From: Simon Davis
Sent: 13 March 2019 11:35
To: Planning.Responses
Subject: FW: BR/270/18/PL - 18-20 London Road, Bognor Regis, PO21 1PY

Env Health (HMO Officer) Response

Re BR/270/18/PL – “Part conversion & extension of existing building to provide 6 No. additional storeys over existing rooftop to provide up to 104 No. student residential units with access from Bedford Street, associated servicing & ancillary accommodation, entrance & new internal stairs to existing building to provide access from Bedford Street.”

B1-Store First Floor
1 : 200

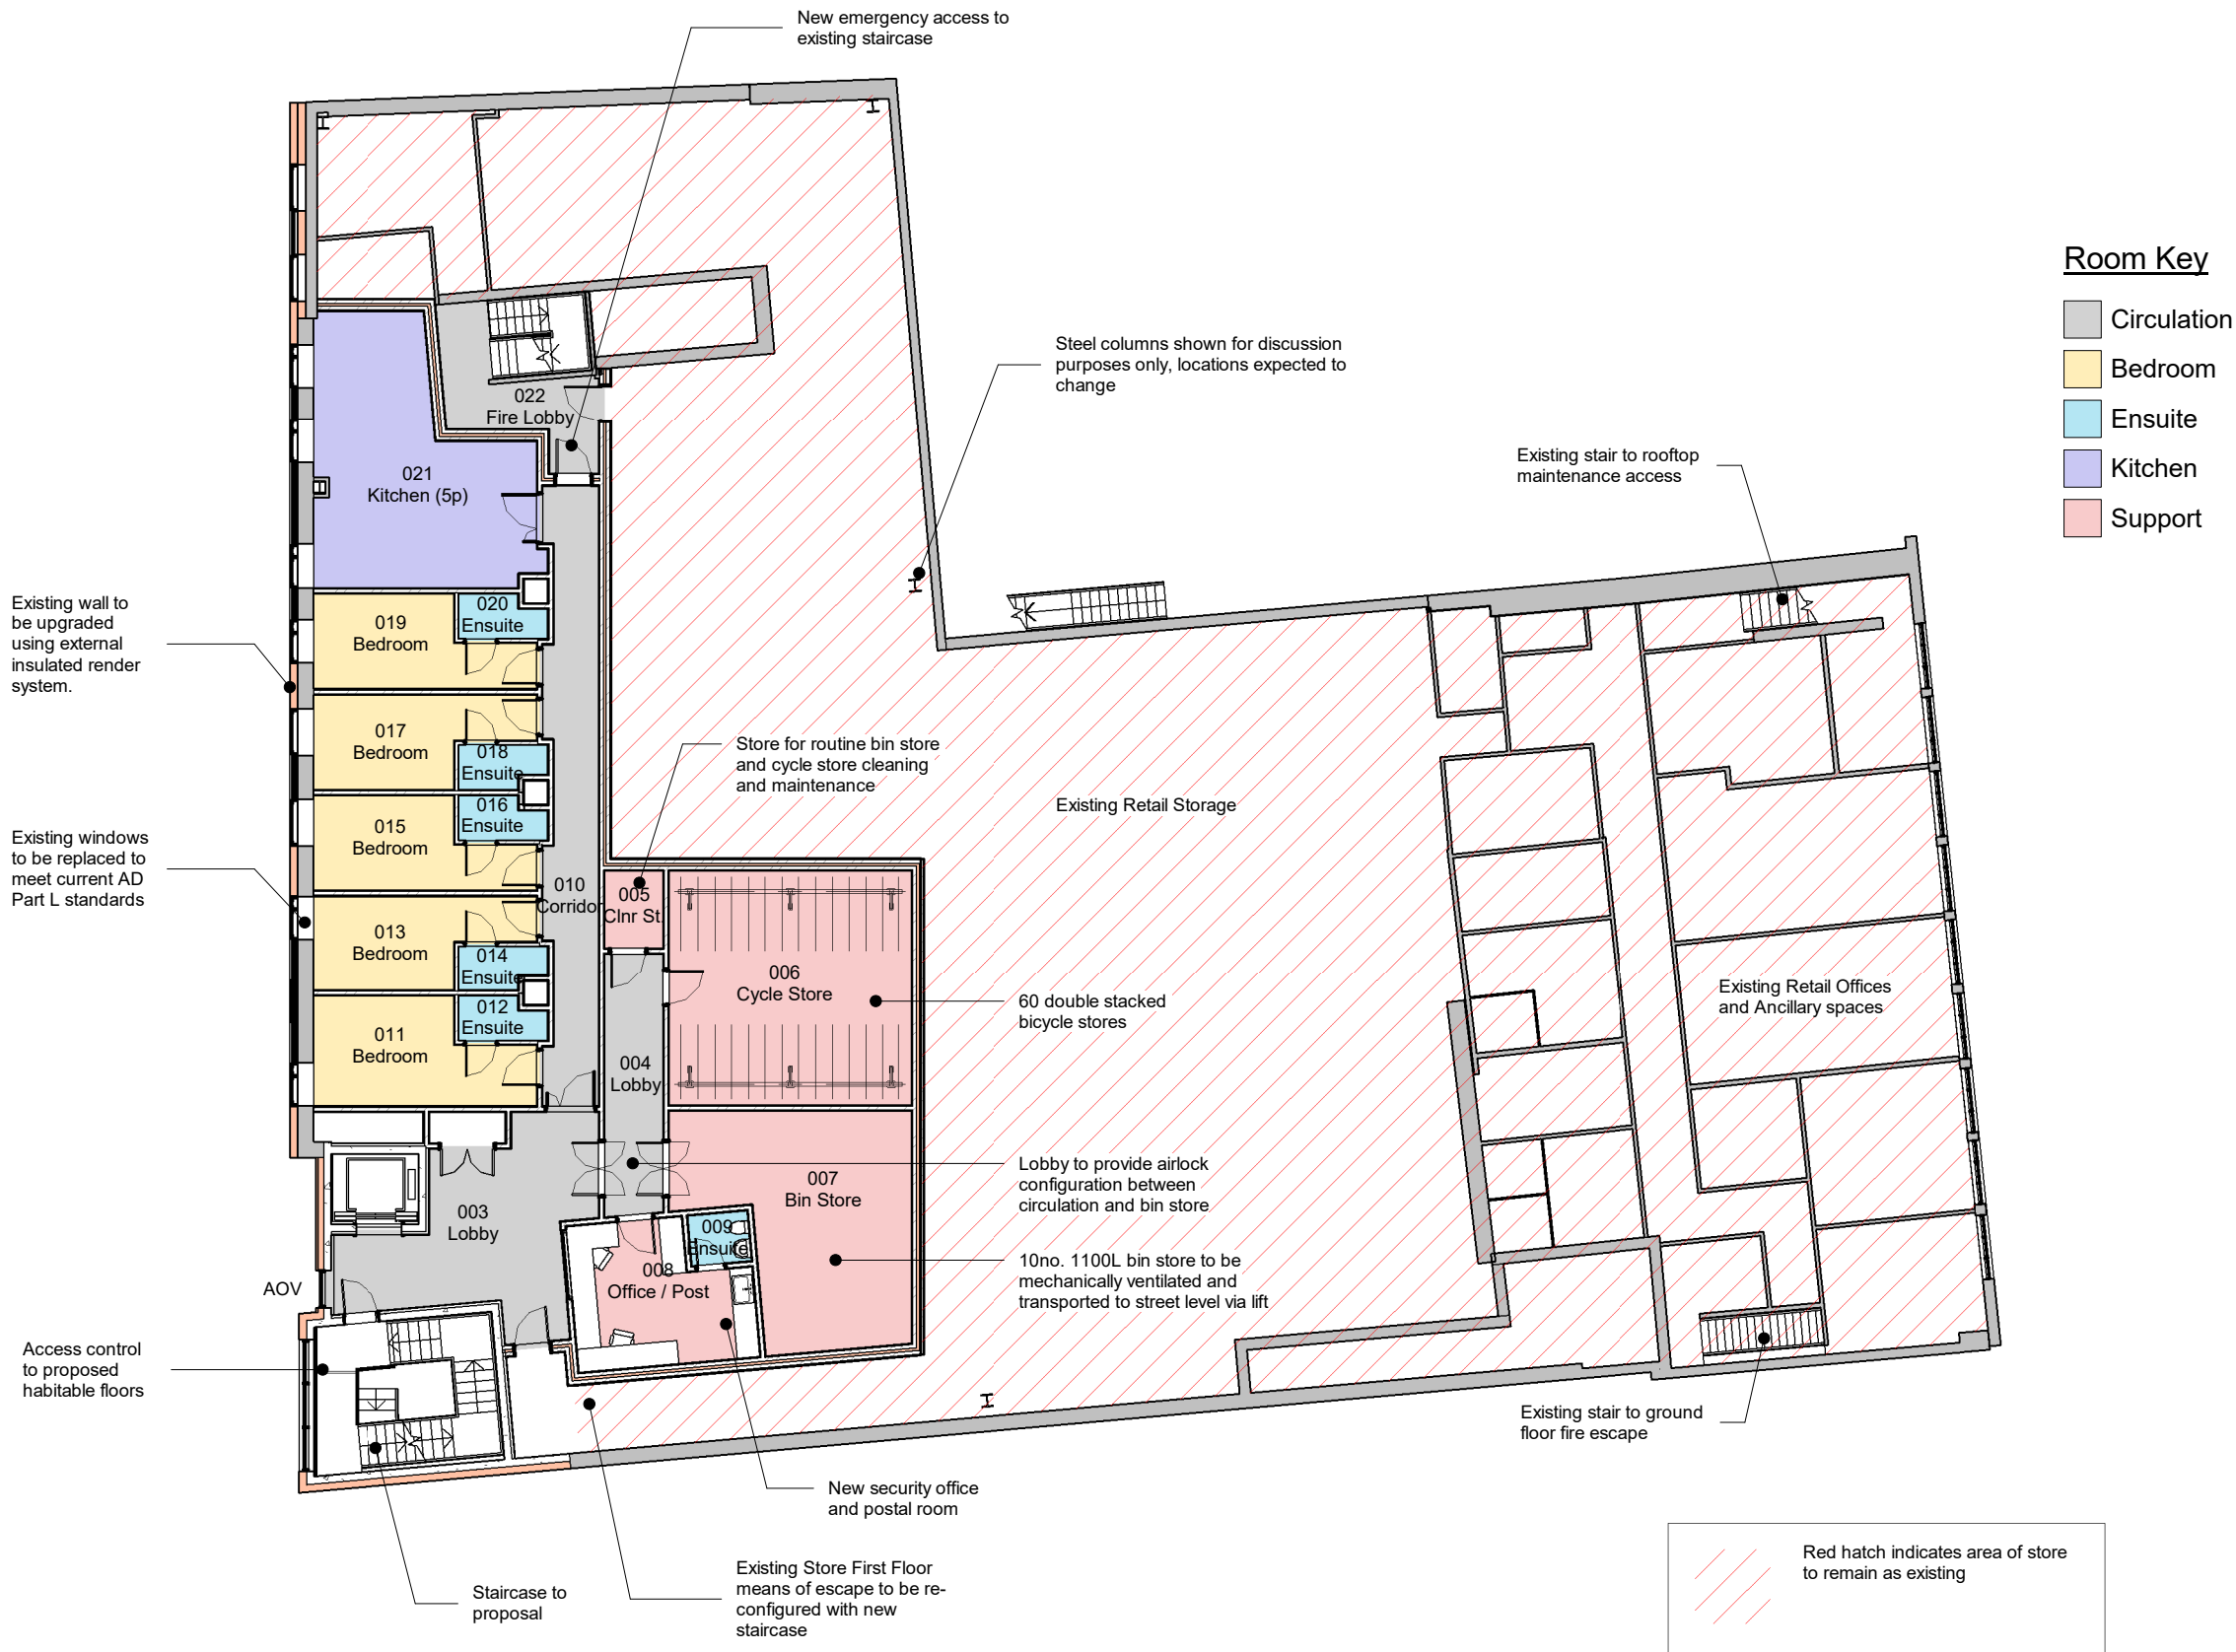
- There is provision for a refuse store which is located on the first floor and collection by the refuse company is internally utilising the lift. I have concerns regarding this arrangement as to whether a refuse company would operate this collection service, if the lift is out of action what are the arrangements, will the same lift be used by the residents, if the residents are requested to put the refuse outside for collection then this could be a considerable amount of waste put on the pavement/roadside for collection which will lead to complaints. Bin stores need to be appropriately managed particularly with this type of internal arrangement to ensure they are cleaned, maintained and do not allow build of waste to help prevent any potential public

health issues. I note that the management plan is to have a live in student warden, however, this may not always be the case if the situation should change or new ownership took over the property.
Should you require any further information or clarification just let me know.
